**Application by Tritax Symmetry (Hinckley) Limited for an Order Granting
Development Consent for the Hinckley National Rail Freight Interchange – Deadline 8
submission**

Comments on Applicant's Deadline 7 submission

Leicestershire County Council final summary

PROPOSED ROUNDABOUT ENTRY WIDENING

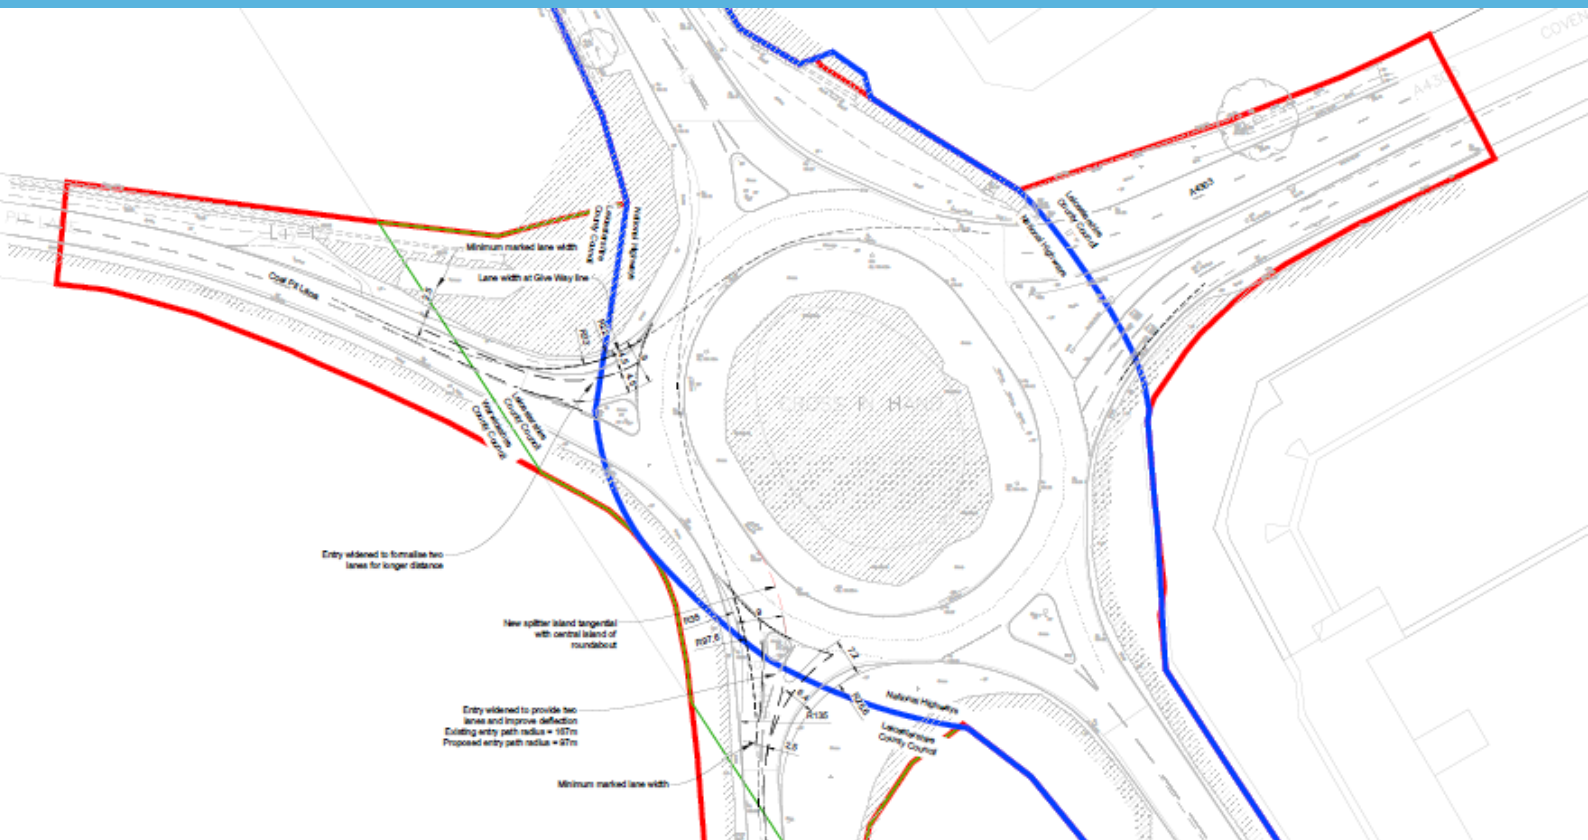
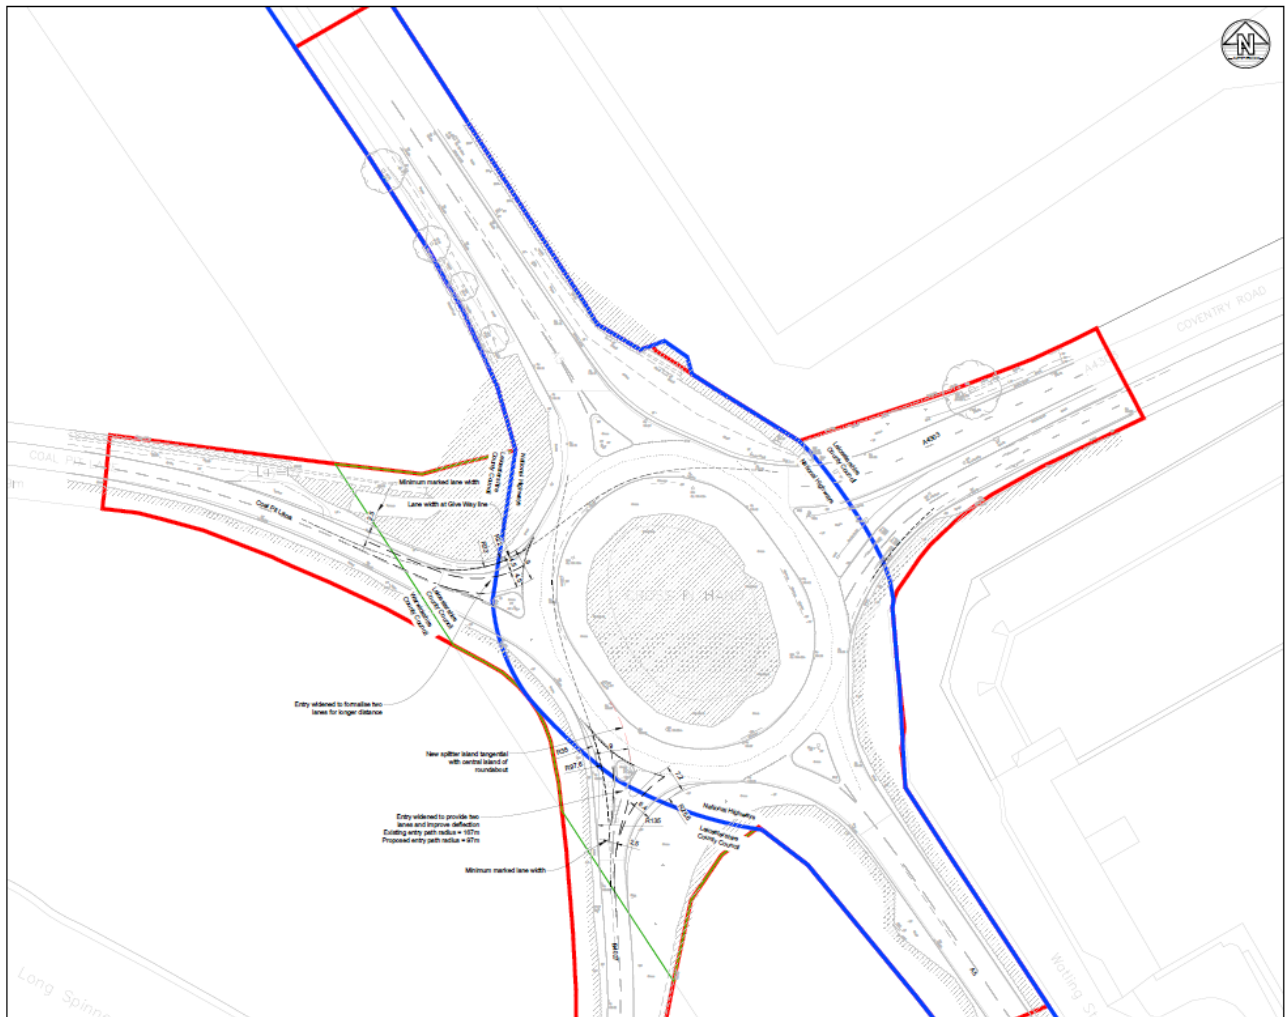
REP7-076	22.2 Hinckley NRFI Transport Technical Note Cross-in-Hand & Gibbet Roundabouts	<p>LCC have reviewed this submitted Technical Note. LCC had not been party to discussions on Gibbet roundabout flows despite two of the arms of the junction being on its network until a meeting held by the Applicant team on 1st March 2024 also attended by National Highways (NH) and Warwickshire County Council (WCC). LCC understand that flows have now been agreed with both National Highways and Warwickshire County Council.</p> <p>However, whilst the Applicant has submitted an Arcady model, this is contrary to the requests of the Highway Authorities. All three Highway Authorities have consistently advised the use of the NH VISSIM model for this junction to accurately replicate the complex movements. This is the approach taken by other developers, including recently by the developers of the Magna Park Distribution Centre. Nonetheless, NH have reviewed the Arcady model and have identified several inaccuracies with the geometric inputs, as well as errors with the conversion of HGV movements into passenger car units. These discrepancies will impact capacity.</p> <p>LCC note that this model (with its inaccuracies) has then been used to develop a scheme of</p>

<p>mitigation. Based on the basic drawing submission, the proposal would appear to do little to increase capacity through the junction and appears to be little more than kerbline tweaks to improve Arcady model outputs. In the absence of VISSIM modelling it is unclear if these tweaks would increase capacity on the ground.</p> <p>This scheme of mitigation has then been costed with no cost breakdown shared with LCC or WCC or verified by NH. Furthermore, the total contribution of £344,967.07 appears to have been inserted into the Unilateral Undertaking (UU) submitted by the developer at Deadline 7 (REP7-049) without the sharing of this information with LCC. Based on the above, LCC cannot confirm that the modelling is accurate, that the proposed scheme will mitigate the impact of the development, nor if the contribution in the UU would be sufficient to implement the scheme.</p> <p>The Applicant team submitted further information to the Highway Authorities on the evening of 5th March 2024 with corrections to the modelling. It is unfortunate that LCC has simply ran out of time in the Examination process to review.</p> <p>Like Gibbet roundabout, LCC had not been party to discussions on flows at Cross-in-Hand roundabout until the meeting on 1st March 2024, despite one of the arms (the A4303 that leads directly to Magna Park and to M1 J20) being on its network.</p> <p>In its Deadline 5 response (REP5-075) LCC highlighted that the Applicant had updated their capacity assessment of the Cross-in-Hand roundabout following new 2023 surveys. The Applicant had reduced the proposed scheme of mitigation to exclude any improvements on the LCC network (A4303). In its Deadline 6 response (REP6-033) LCC stated that initial reviews had identified concerns with the interpretation of the survey data and the associated furnishing methodology. It now appears that these flows have been amended.</p> <p>The flows now increase the amount of traffic predicted to use the A4303 and therefore LCC is concerned that the mitigation on this arm previously proposed and then omitted may need to form part of the mitigation strategy. It is unfortunate that this information has been submitted too late in the examination process for LCC to review the revised modelling in any detail.</p>

Therefore, uncertainty remains as to whether the impact of the development at the Cross-in-Hand roundabout can be mitigated by the proposed scheme.
REP7-063	18.20 Applicant's response to Deadline 6 Submissions [part 3 - LCC]	LCC note the Applicant team's response to the LCC detailed design review submitted at Deadline 6 (REP6-033). LCC note that the Applicant team has committed to addressing some of the comments at detailed design stage, others have been disregarded. Where these comments have been dismissed, LCC will raise these again through any future technical approval process to ensure compliance with both local and national design standards to ensure that a safe and appropriate scheme is delivered. LCC await with interest the findings of the Stage 1 Road Safety Audits to see if they raise the same or similar issues to those raised through the interim Road Safety Audit process and highlighted again by LCC in its detailed design review. It is understood that the Applicant will submit Stage 1 Road Safety Audits to the ExA at Deadline 8. It is unfortunate that LCC will not therefore have any further opportunity to review and comment.
